Re: Objection to MP08_0244 MOD 1 Modification Request for Mixed Used Development at 23-37 Lindfield Avenue and 11 Havilah Lane, Lindfield

As a resident of Lindfield, I/we wish to lodge an objection against the proposed Modification of the subject development based on the following grounds:

3 SHADOW DIAGRAM - 21stDEC_3PM
5003 SCALE1 : 650

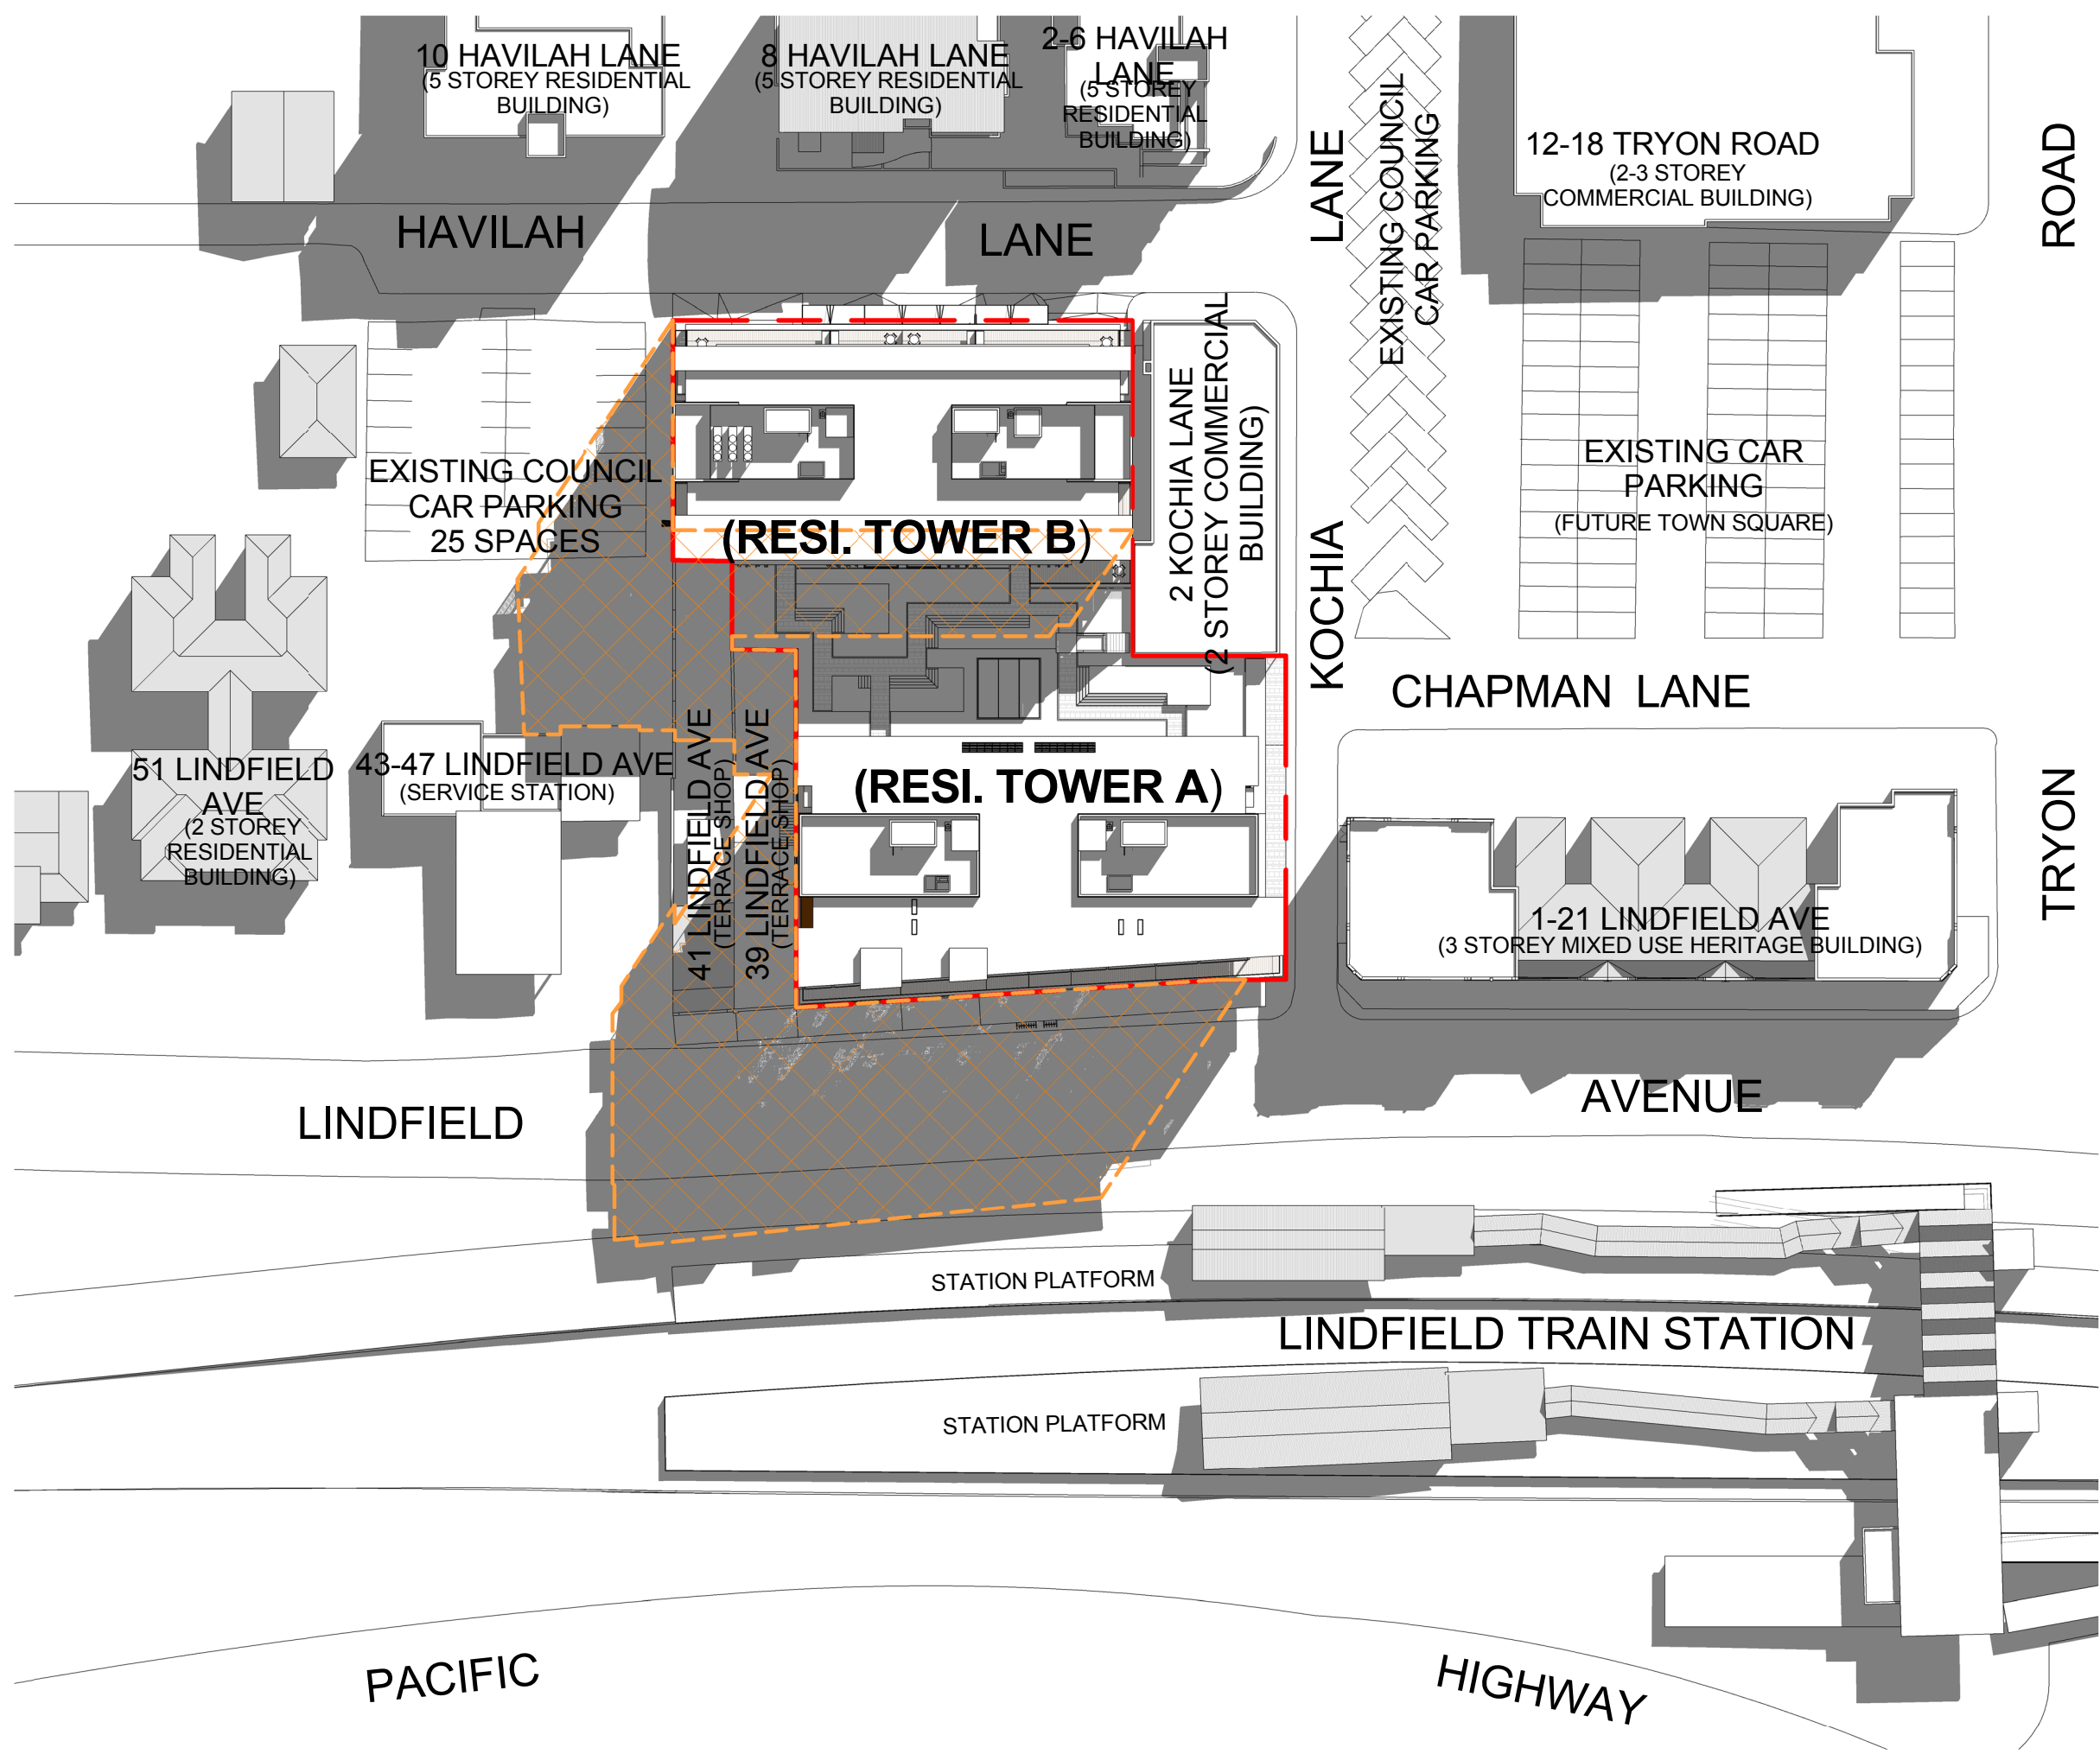
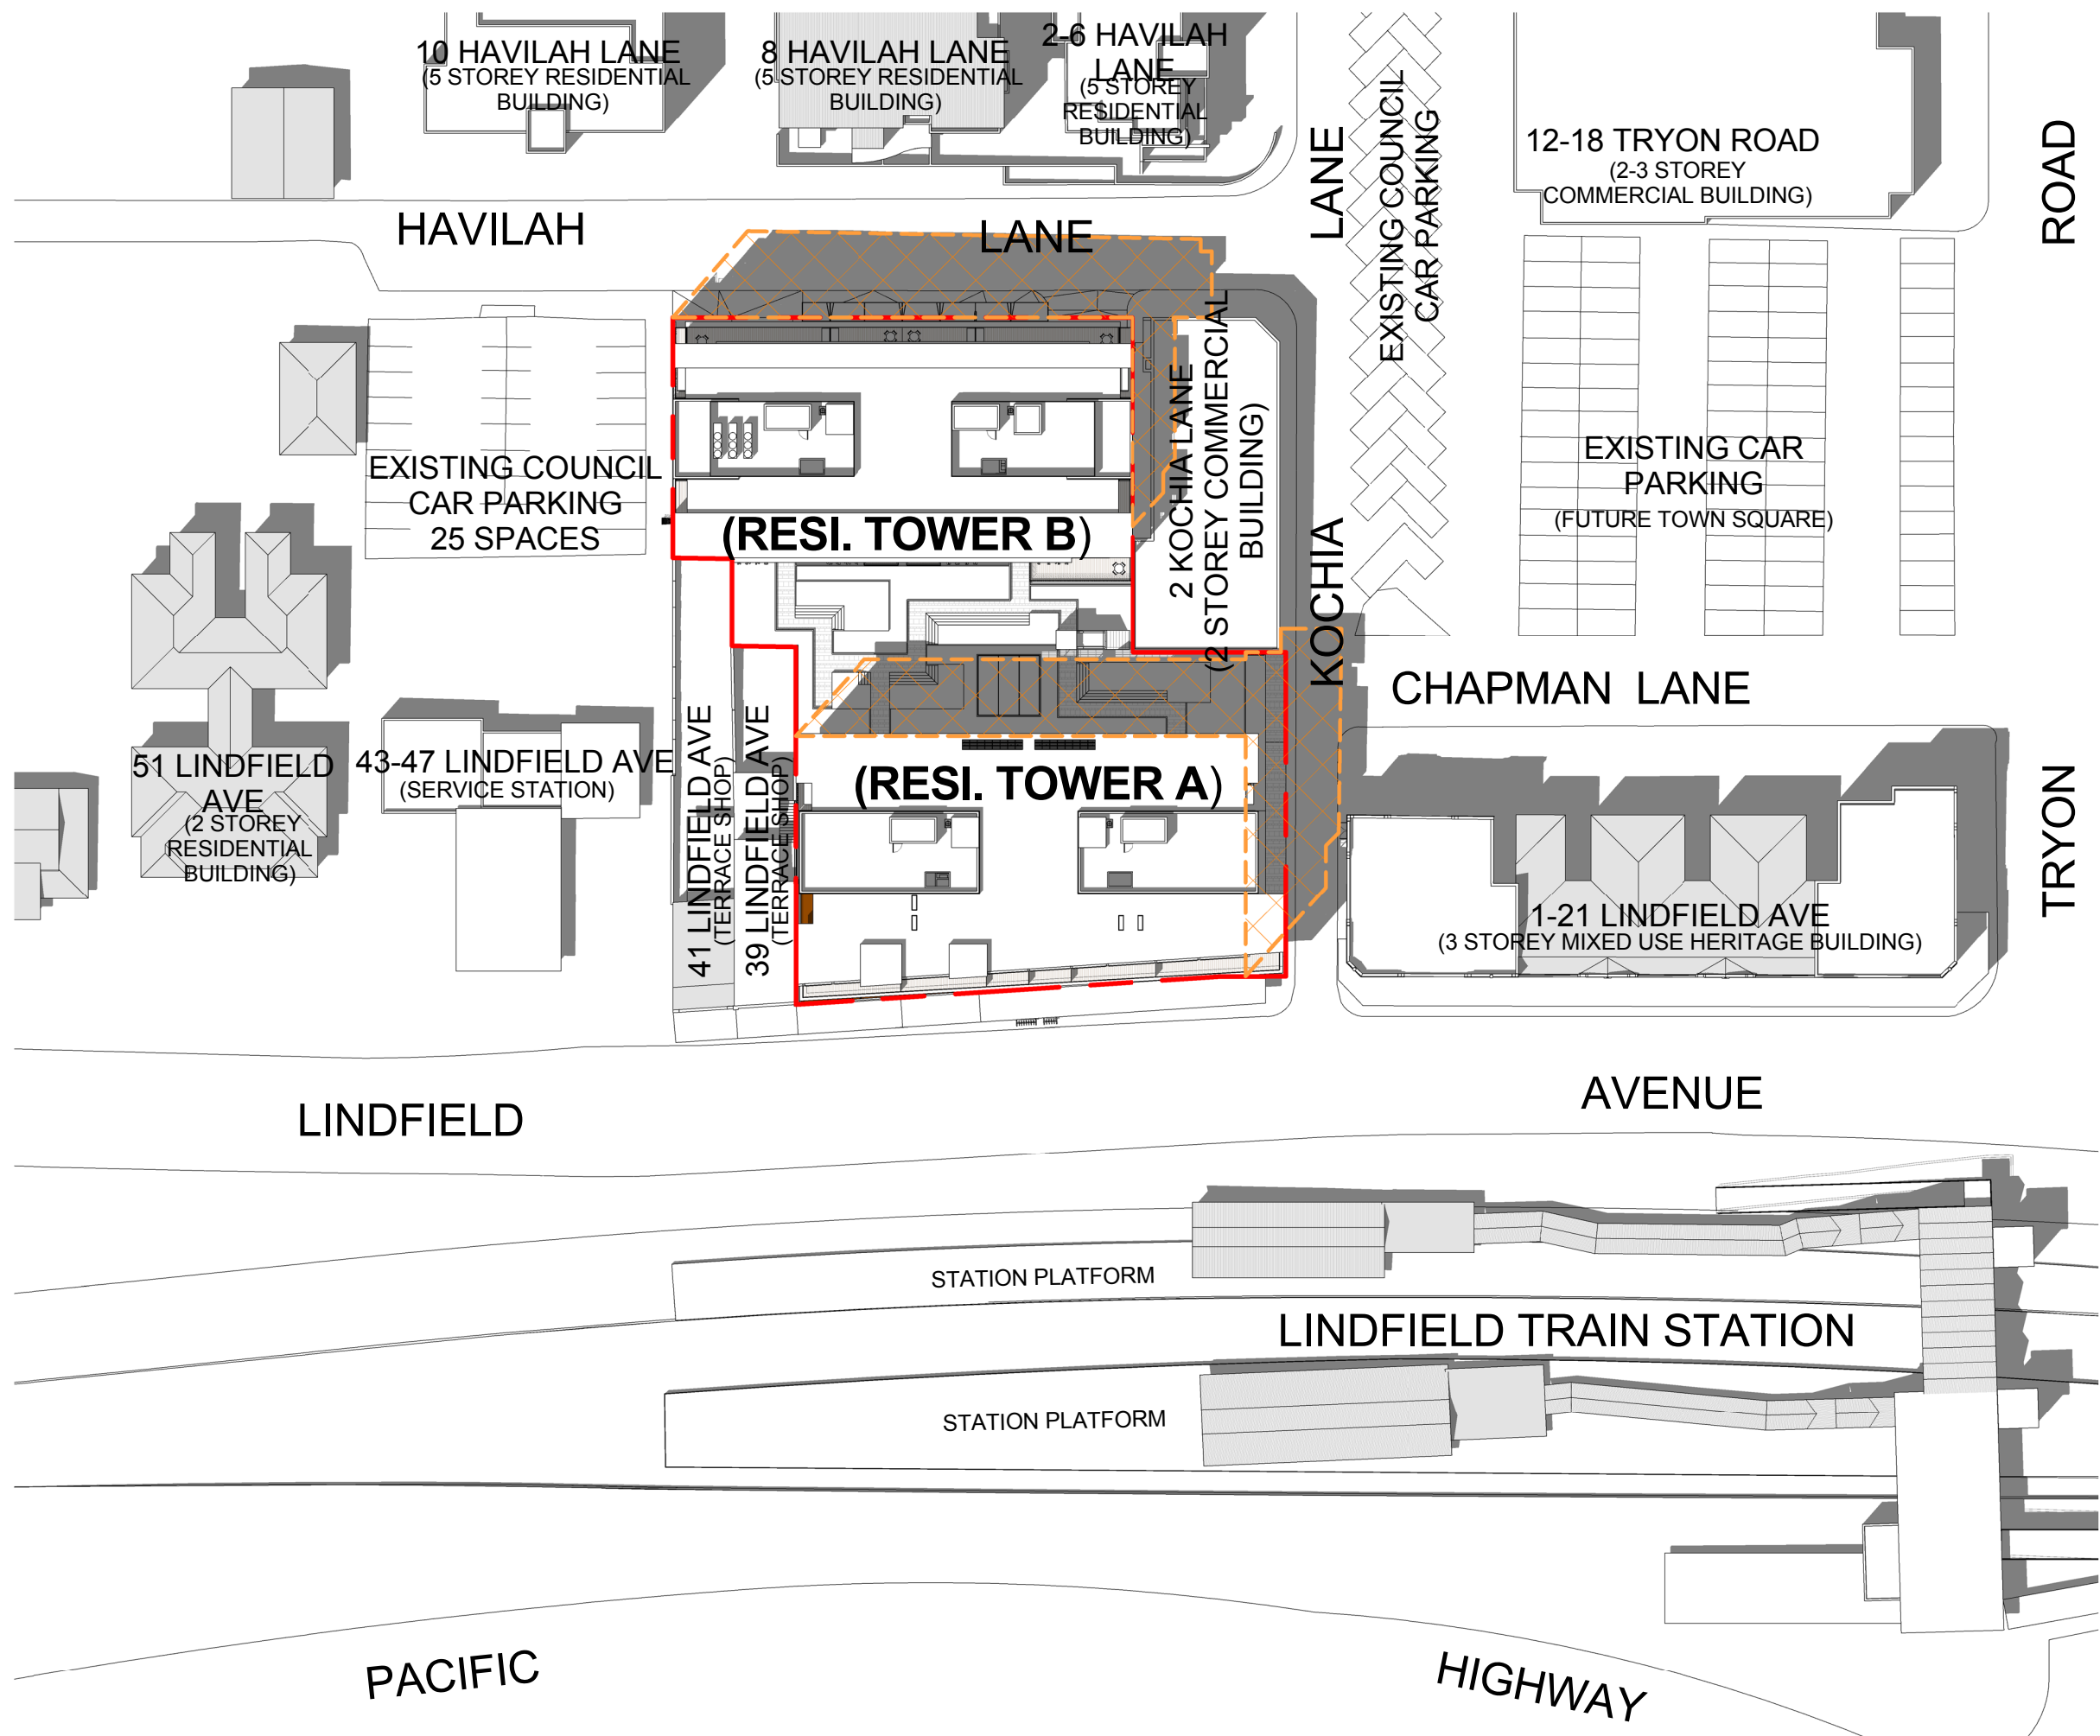
- The additional storeys create new adverse shadowing: a) for residents in the Havilah Lane apartments, particularly after 3pm b) for the popular outdoor café and central Lindfield hub area at 12 Tryon Road in afternoons, particularly in winter and c) for all commuters on the city bound Lindfield rail platform, instead of 50% of the year as approved, it will now be in shadow in the mornings 75% of the year
